CITY OF ALBUQUERQUE

May 19, 2016

**Re: McDonald's at San Mateo and Academy
Request for Permanent C.O. - Not Accepted
Engineer's Stamp Date 2-9-16 (E18D019C)
Certification date: 5-18-16**

C7.0

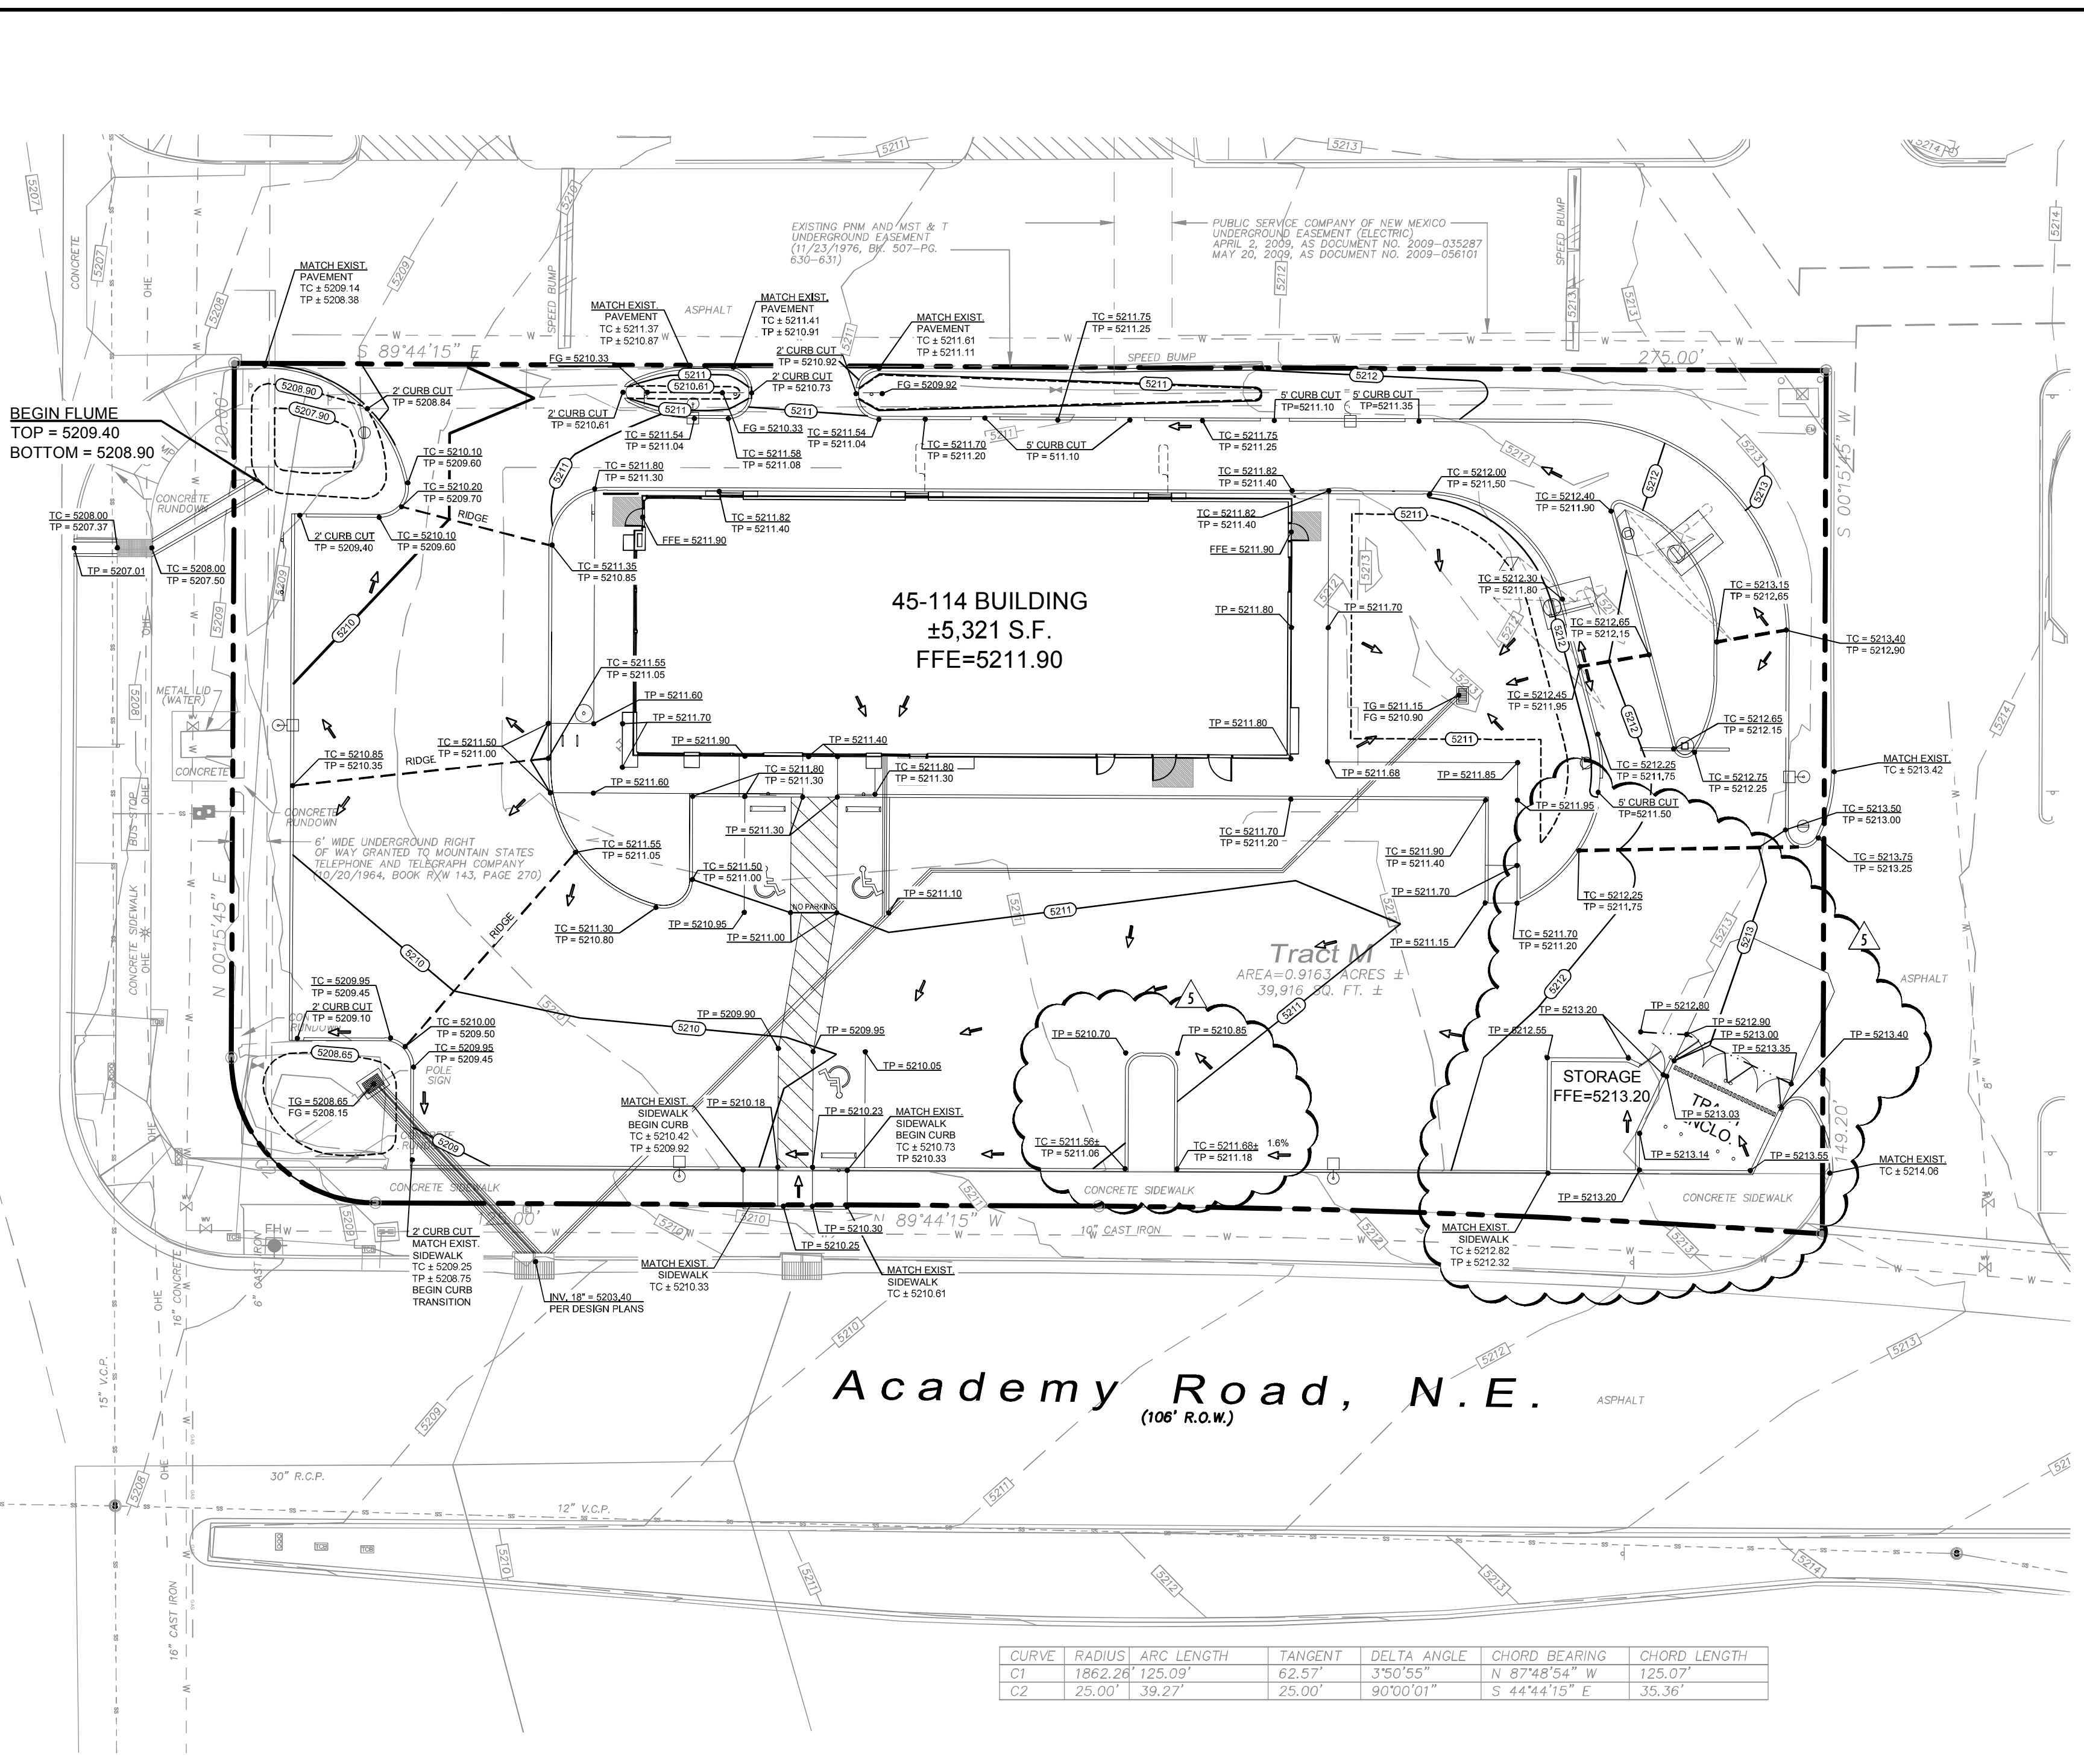
1. The swale on the NW corner was not constructed per the approved plan. Water must not drain into the right-of-way. Attached is a copy of an option on how to address the flows.
